**Consultation Response from KC,
Trees**

**2026/92441 Disused Railway Embankment, off Crosland Factory Lane to Fold Farm Lane,
Netherton, Huddersfield, HD4 7FB**

**Formation of accessible, 755m long path for walking, wheeling and cycling primarily along the
top of a disused railway embankment**

Date Responded: 28/09/2026

Appendix 1: Arboricultural Impact Assessment Plan - Sheet-plan

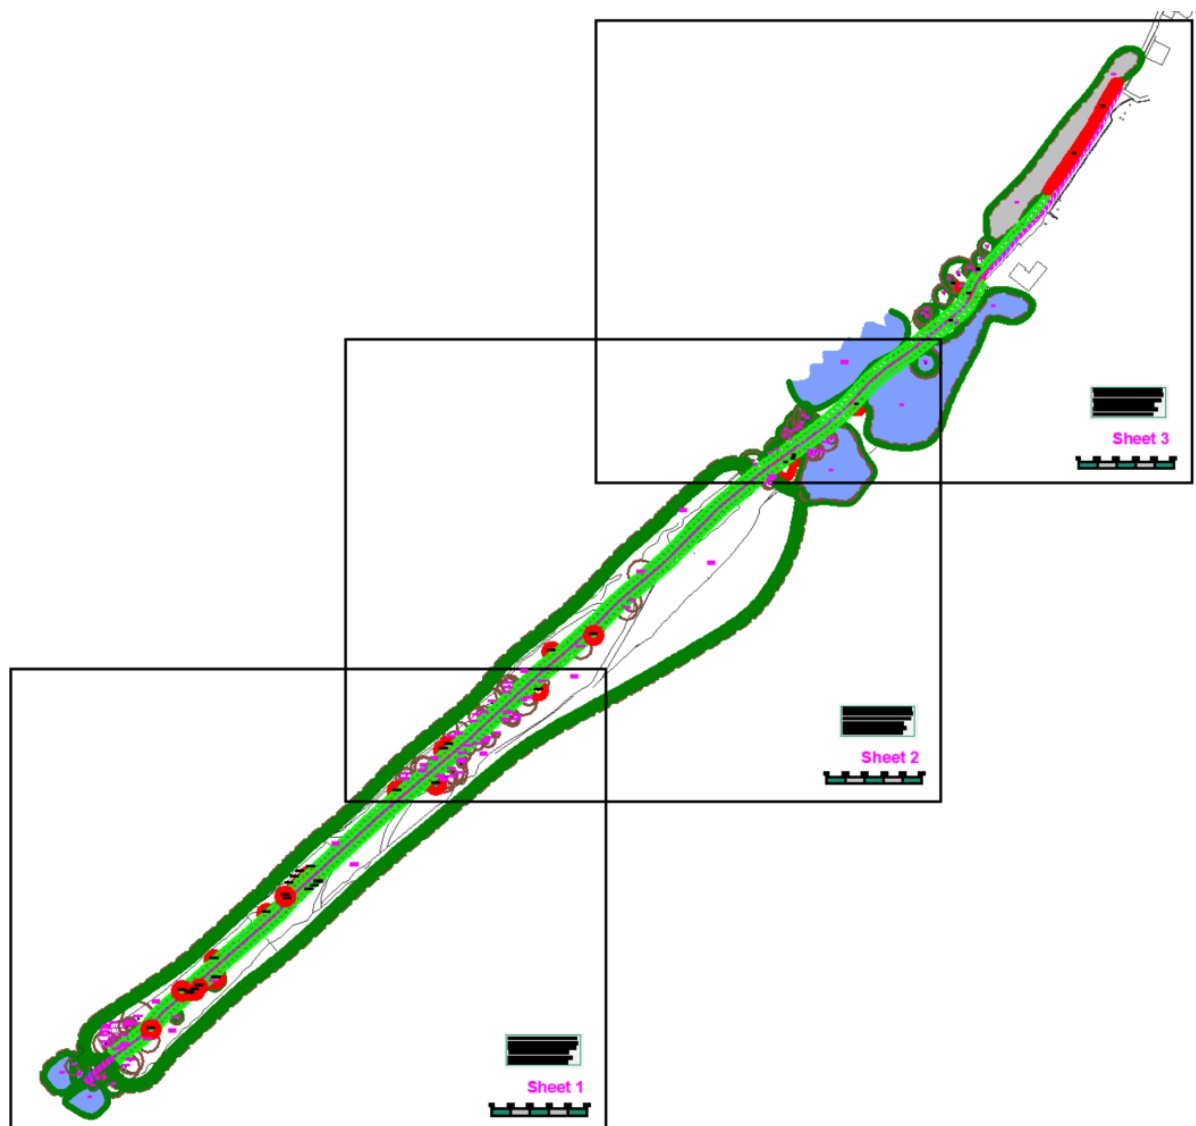
The proposed removal of trees to facilitate the development is targeted and sensitive in selection. With 14 category U trees to be removed (trees which require removal for Arboricultural reasons anyway), 17 category C trees (lower value trees which are considered to be removed to facilitate development) and only 1 category B tree to be removed. There is also part of a category C group to be removed.

Over all the recommended tree removals is deemed appropriate and acceptable by KC trees. It has taken the minimal amount possible to achieve the proposals and isn't gathered in any one particular area which should disrupt the landscape.

Having said that these are all TPO'd trees and would require a replacement tree to be planted for every tree removed (same species and as close to the original location as reasonably practicable).

There is no objection from KC trees to the proposals providing an Arboricultural Method Statement is secured via condition and that a replacement planting scheme is included in said method statement or as a separate document.

The method statement should include how other retained trees are to be protected from soil compaction, accidental damage and storage of any materials.
